FW: Planning Application BN/130/25/PL - The Former Croft Surgery

I am writing to introduce myself in relation to planning application BN/130/25/PL, proposing the change of use of The Former Croft Surgery, Barnham Road, Eastergate, to a place of worship. We are acting on behalf of our client, Chalcroft Gospel Hall Trust.

Proposed Ground Floor Plan

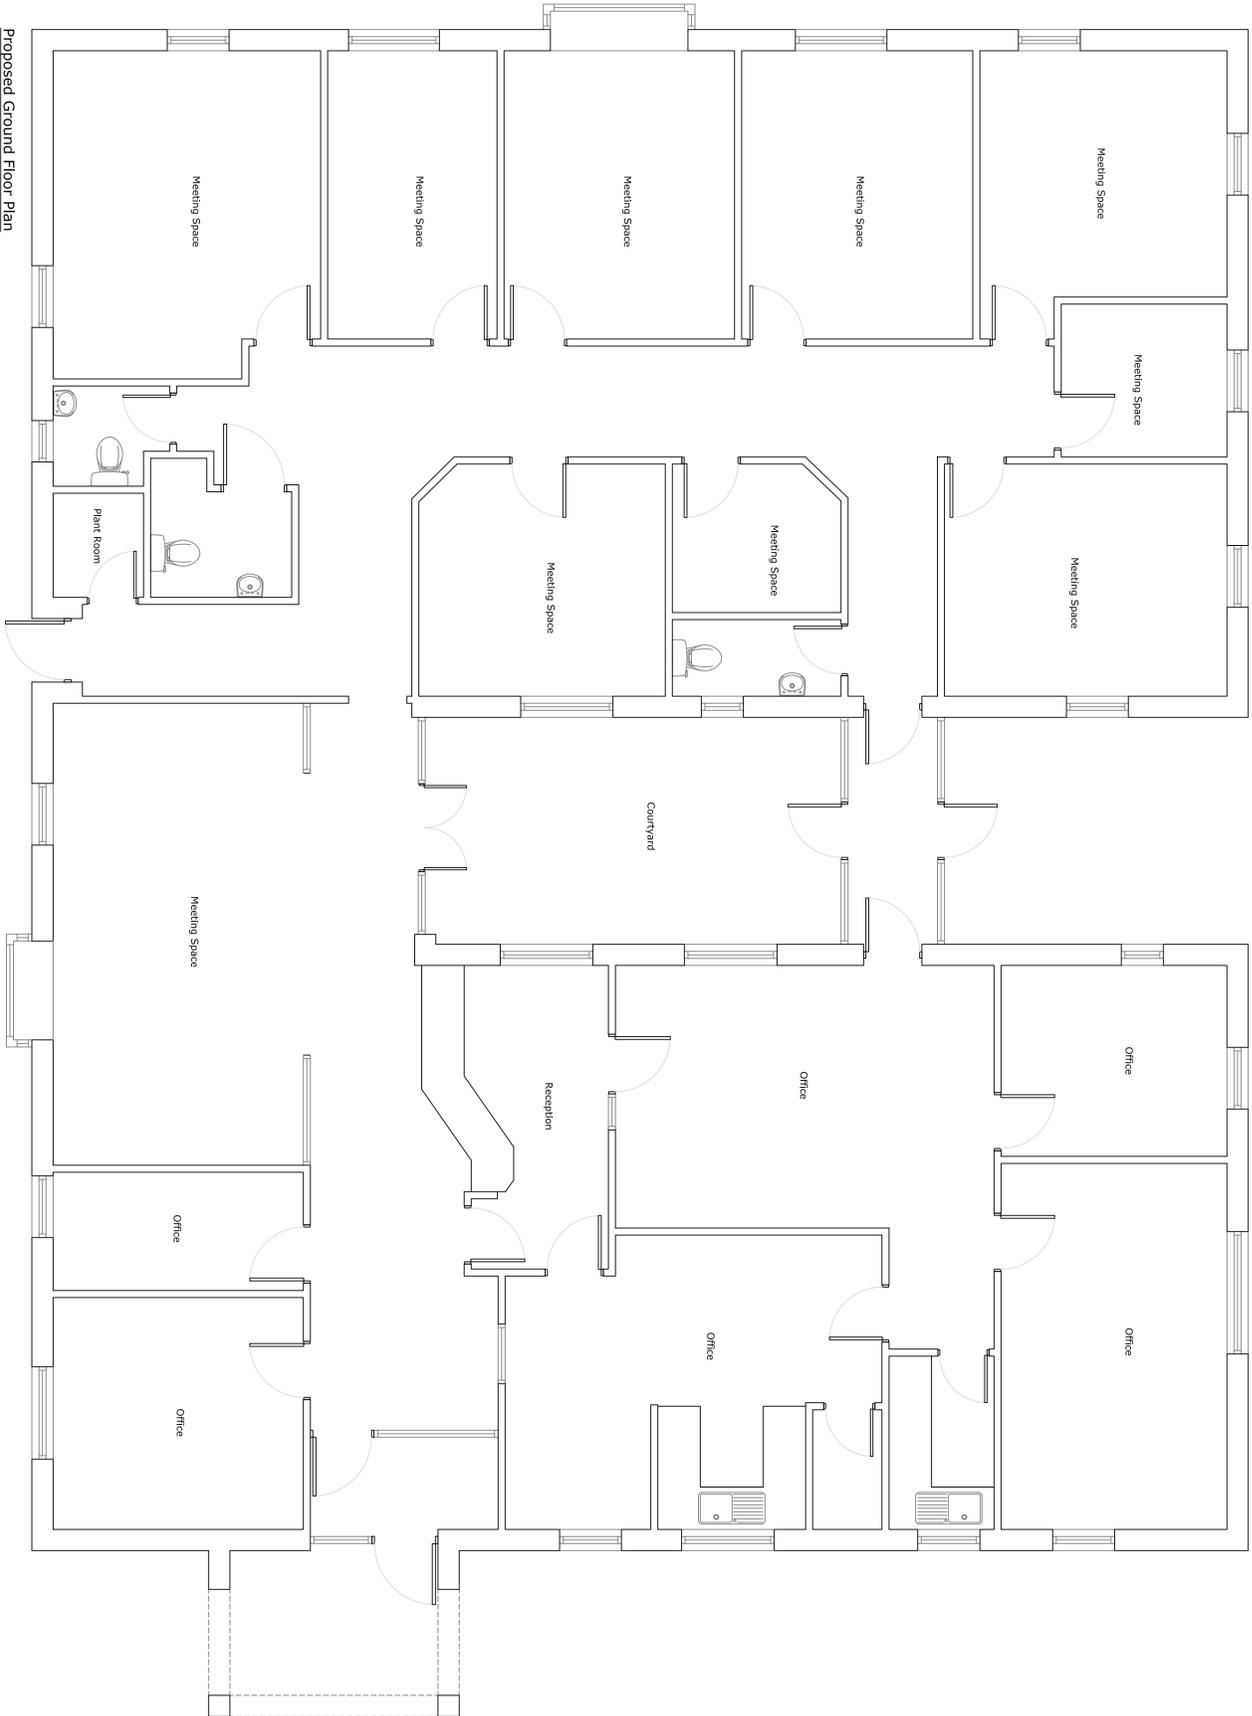
I just have a question regarding the general arrangement of the place of worship. The Proposed Floor Plan shows several meeting spaces (unchanged from existing). Is this how the church operates in smaller groups rather than having one larger area for congregation within the building?

In response to questions 1 and 2, the principal meeting and worship area for the proposed use will be the former GP surgery waiting room. The smaller former consulting rooms will be used only for ancillary purposes, including administration, private pastoral meetings between members of the congregation, and storage. These rooms will not function as separate activity areas or support any form of multi-use community operation in addition to the twice per week congregation. The expected attendance remains as set out in the Planning Statement and as follows: a maximum congregation of 30–40 individuals attending only twice per week (Monday evenings and Sunday mornings). This compares as follows to the former GP use, which regularly accommodated 45–50 people at peak times at full room capacity throughout the full working day. The proposal therefore represents a clear and demonstrable de-intensification of use and will generate significantly fewer trips than the historic established use.

In response to your query, the Applicant has confirmed that, given the size of the congregation, they will be adequately accommodated within the proposed meeting room located in the existing GP Surgery's former waiting area. The smaller meeting rooms will serve, where applicable, for occasions when the Church meets in smaller groups.
